TPS Transport Consultants Ltd

Transport Assessment Addendum

Client	Newett Homes
Project	Shepley Road, Stocksmoor
TPS Reference	P2835
Date Prepared	04.04.25
Prepared By	JT
Checked By	CG

- 1.2 A highways consultation response has been received from Kirklees Council (KC), pursuant to planning application ref: 2024/91242 (KC Responding Ref: 12-33/18). The full consultation response, dated 14th October 2024 is attached at **Appendix A**.

Drawing: KIRKLEES REFUSE VEHICLE SWEEP PATH ANALYSIS

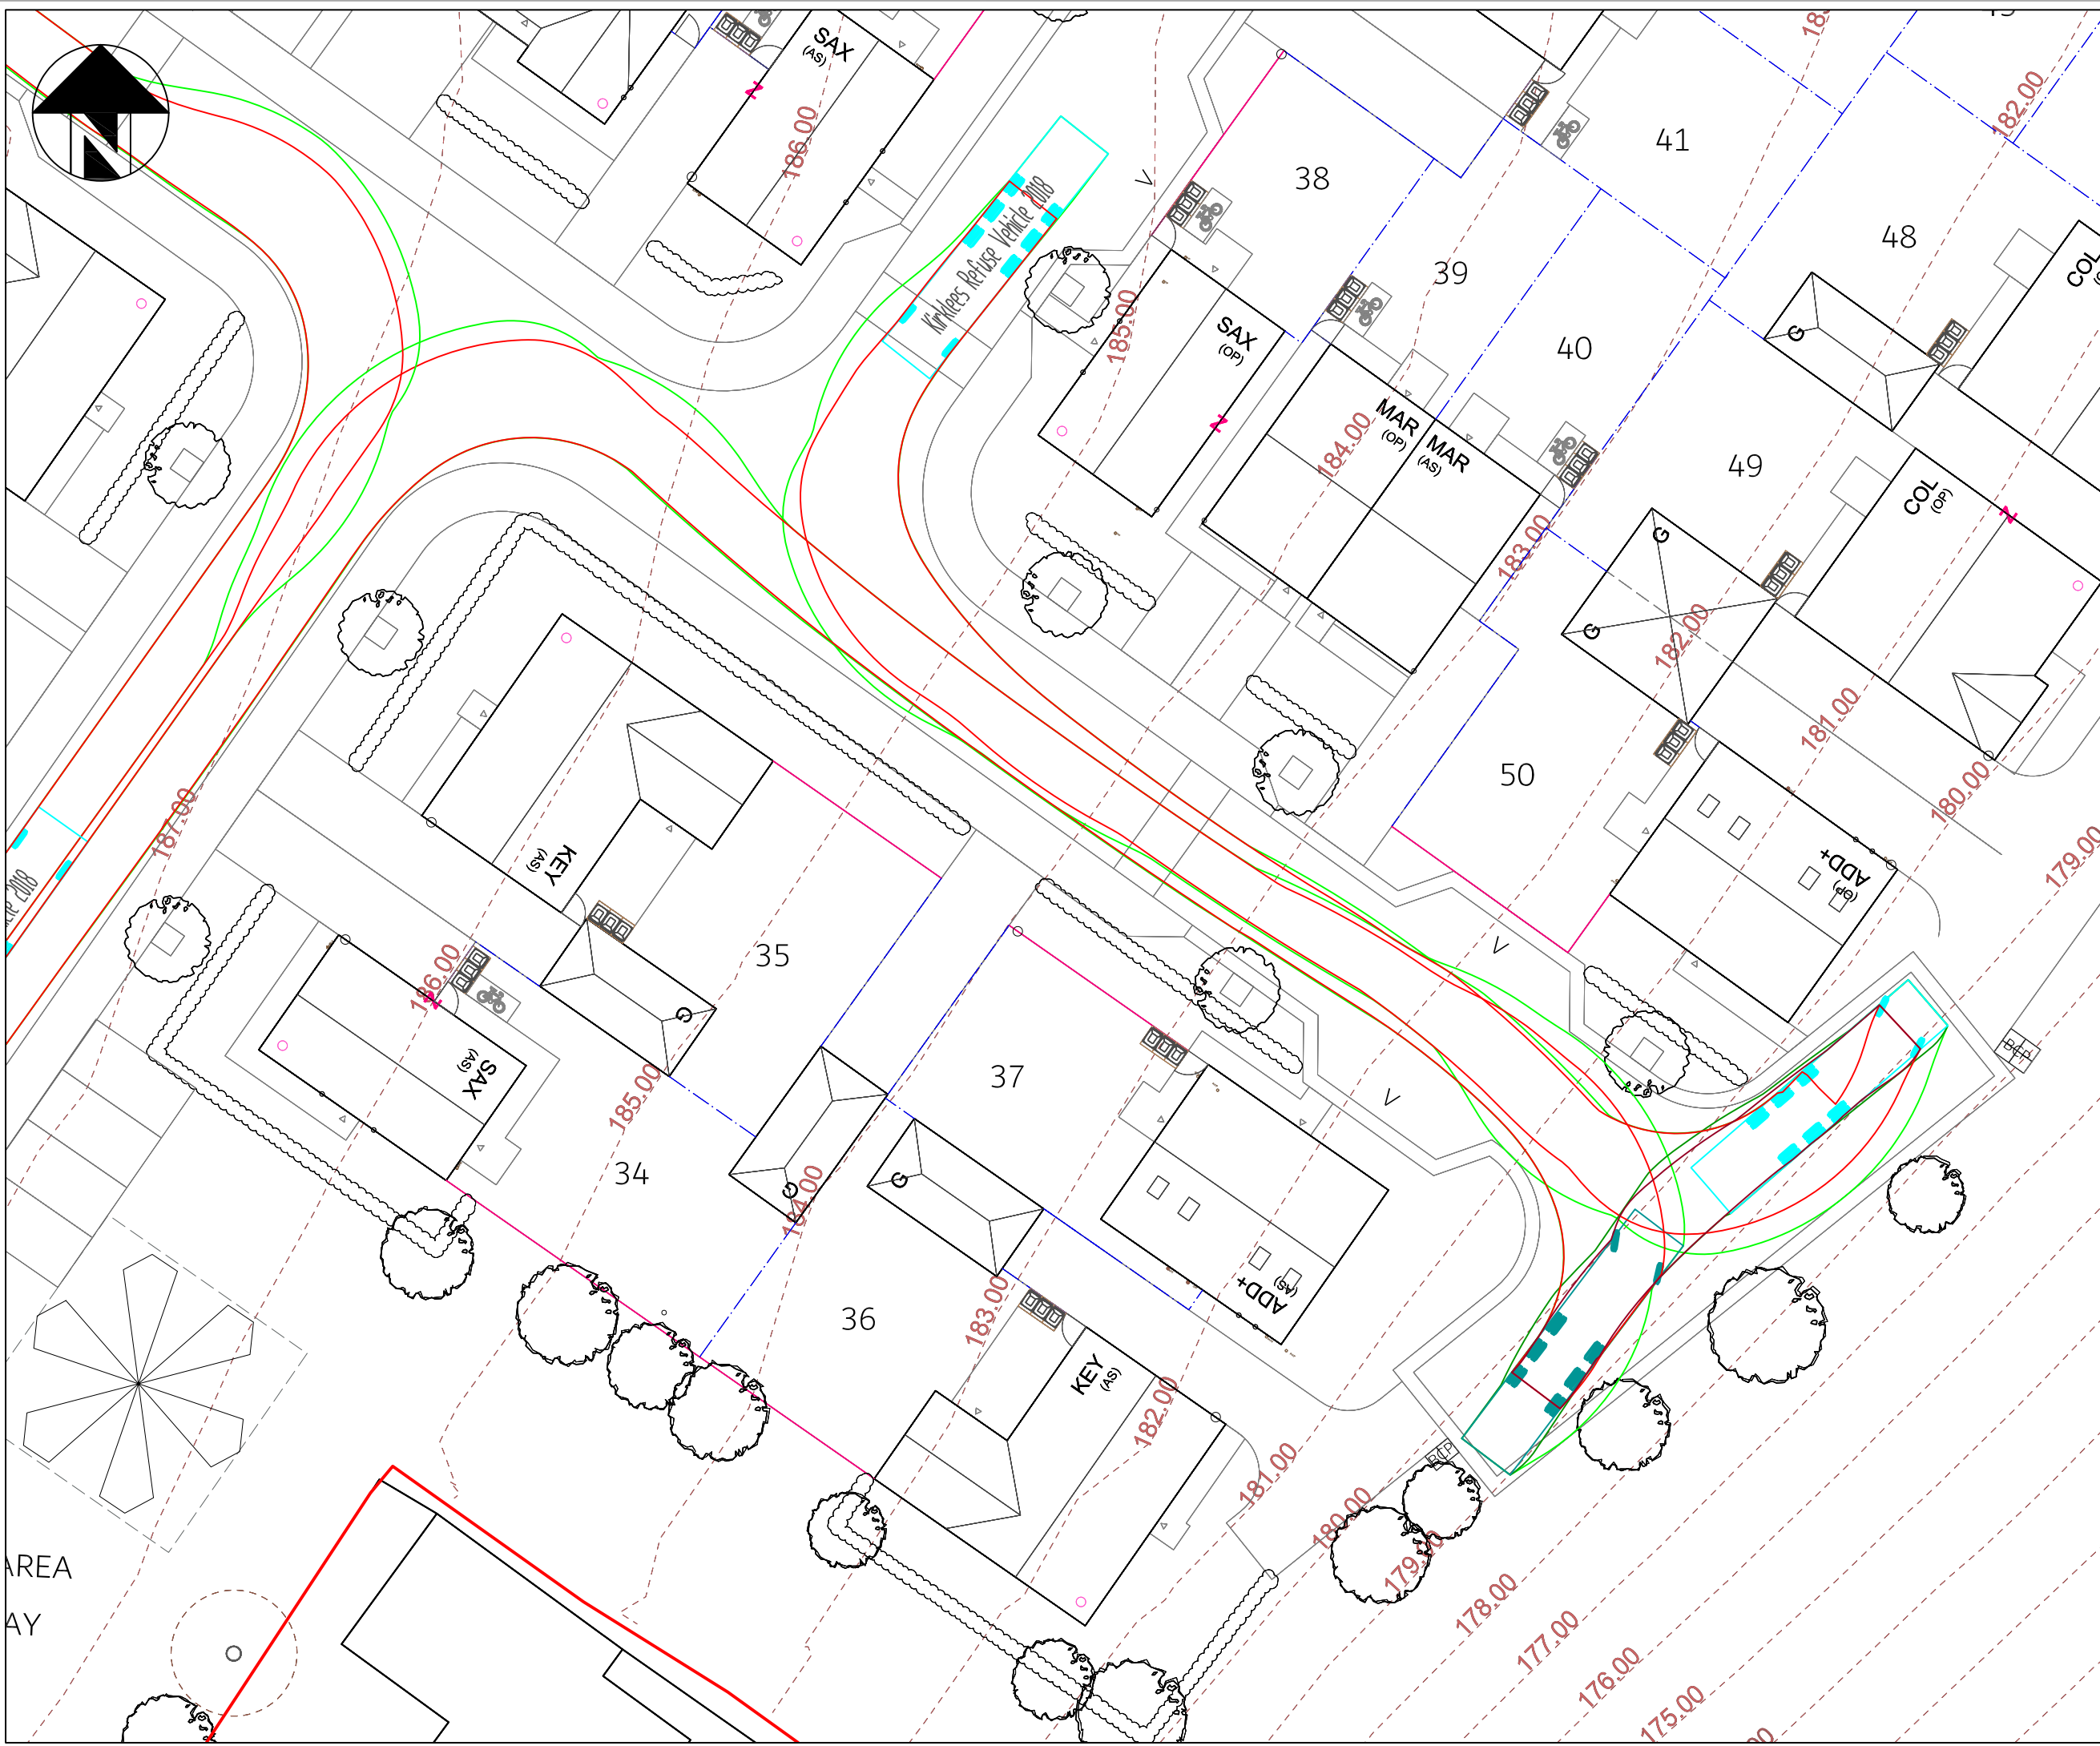
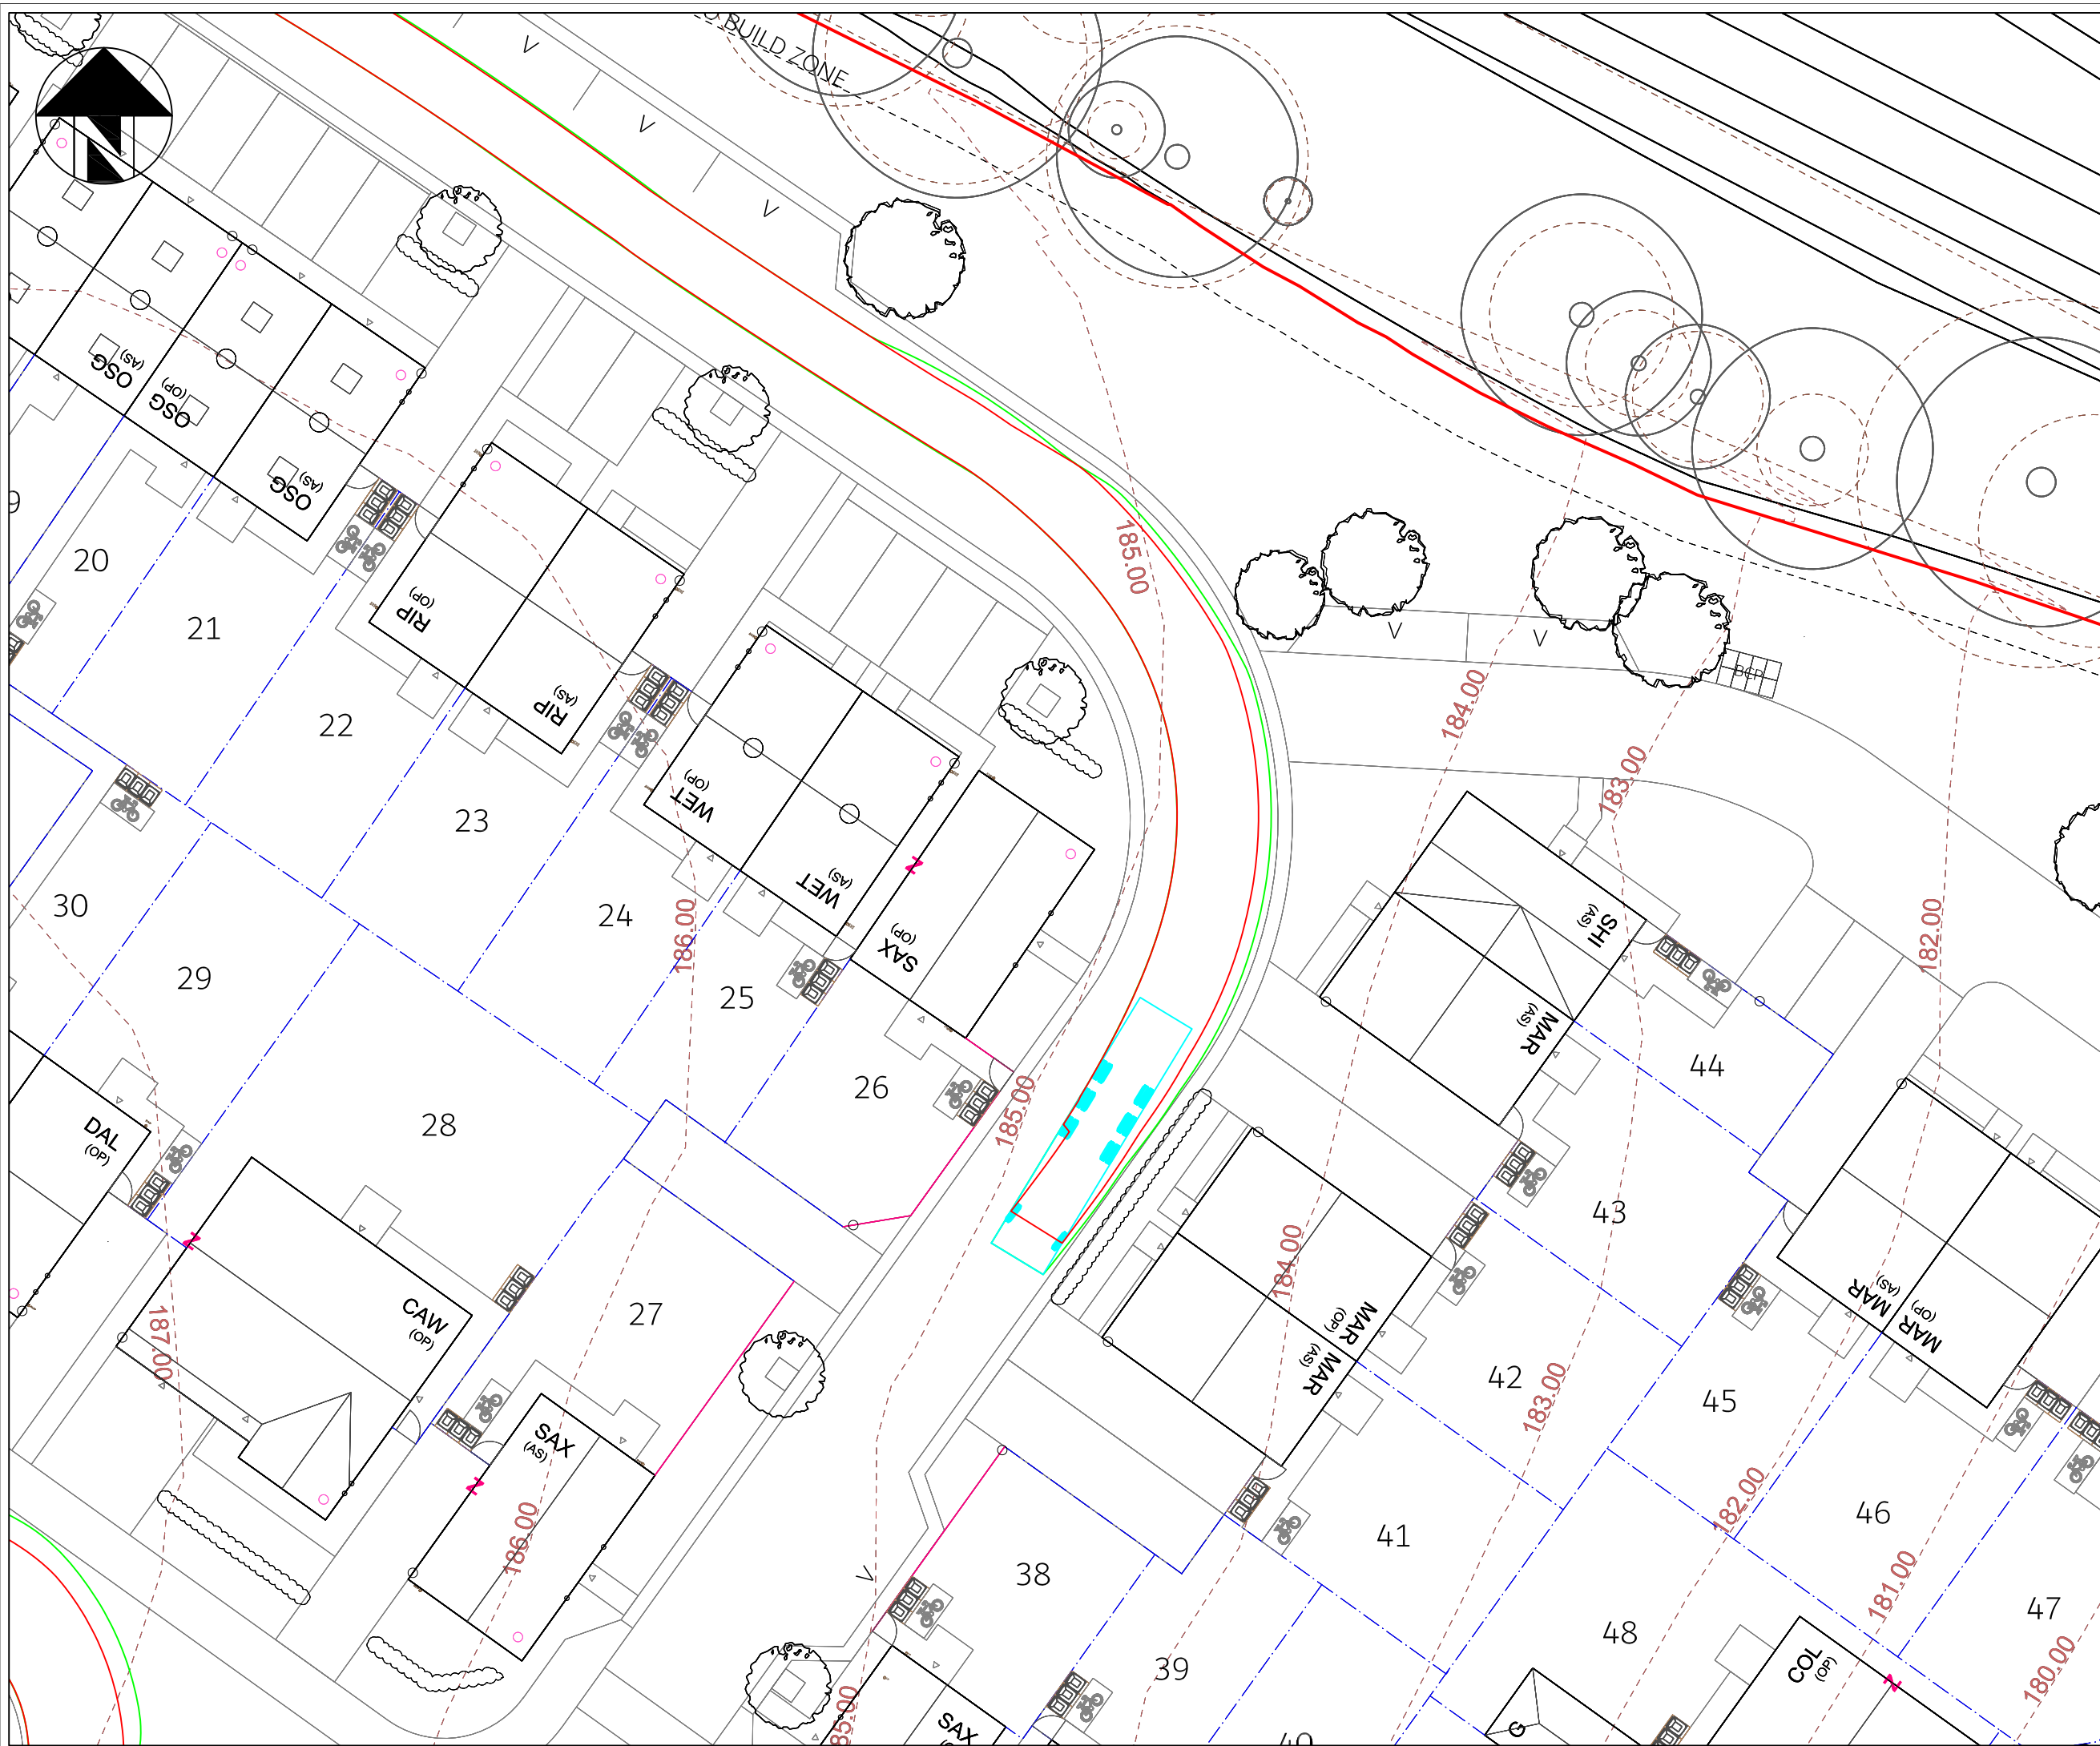
- The horizontal and vertical alignment models of the proposed site access have been updated to address comments raised in the KC consultation response and further comments provided via email. The bend has been widened to better accommodate the swept path analysis of a refuse vehicle passing a car waiting to turn right into the site. There is 0.389m clearance between the refuse vehicle and the car;
